Engineers Comments Regarding Condition 5, 6 and 7

APPLICATION NO: BN/59/19/DOC

Site Address: Land Adjacent 4 Lake Lane Barnham PO22 0AD

Description of Works: Approval of details reserved by condition imposed under ref BN/23/15/PL relating to Condition Nos 5 - surface water drainage, 6 - consent for discharge of any flows to watercourses, 7 - future access & maintenance of watercourses or culverts.

|        | 4 Lake Lane<br>Barnham<br>West Sussex | Surface water<br>drainage plan | Planning    | CB       | CB             |

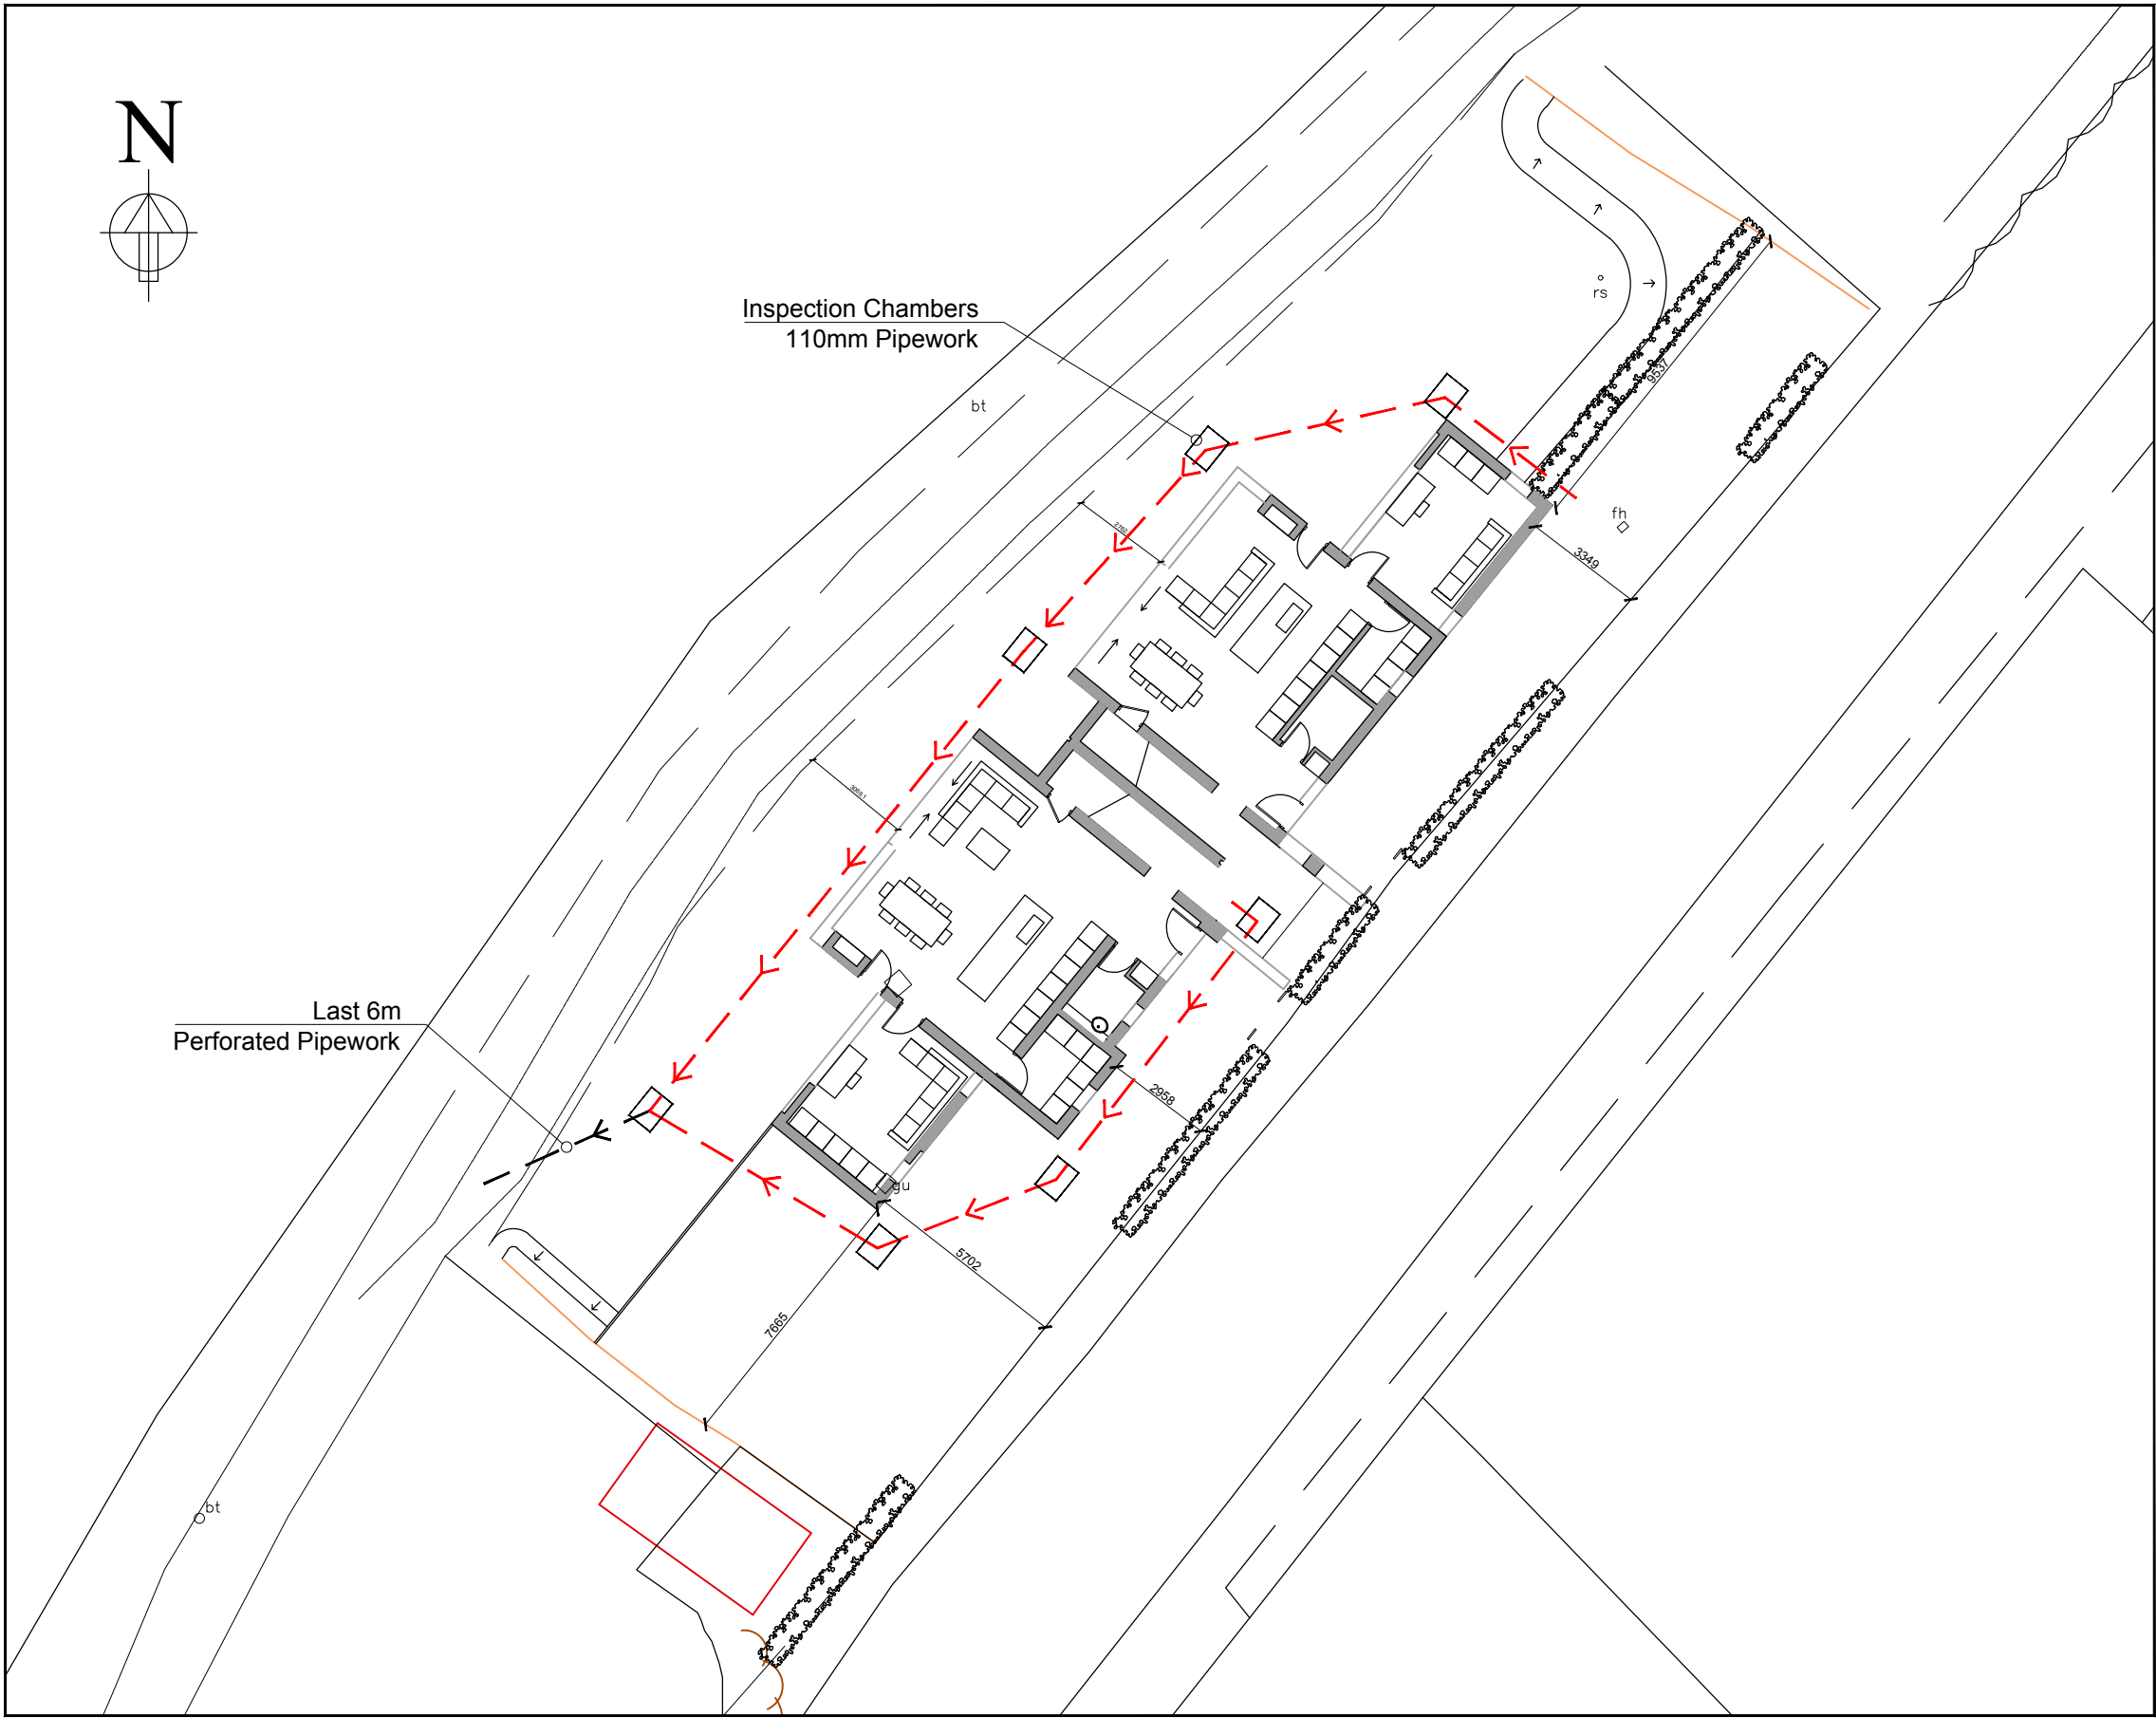
A drainage plan has been supplied along with an environment agency permit. No details of the surface water drainage proposals have been provided evidencing how the hierarchy for sustainable drainage is being followed.

The applicant must submit groundwater monitoring results, infiltration testing results, calculations, construction detail drawings and a more detailed layout plan. For exact details of our requirements for a DOC application the applicant is advised to look at and complete our checklist, located here: <https://www.arun.gov.uk/drainagechecklist>.
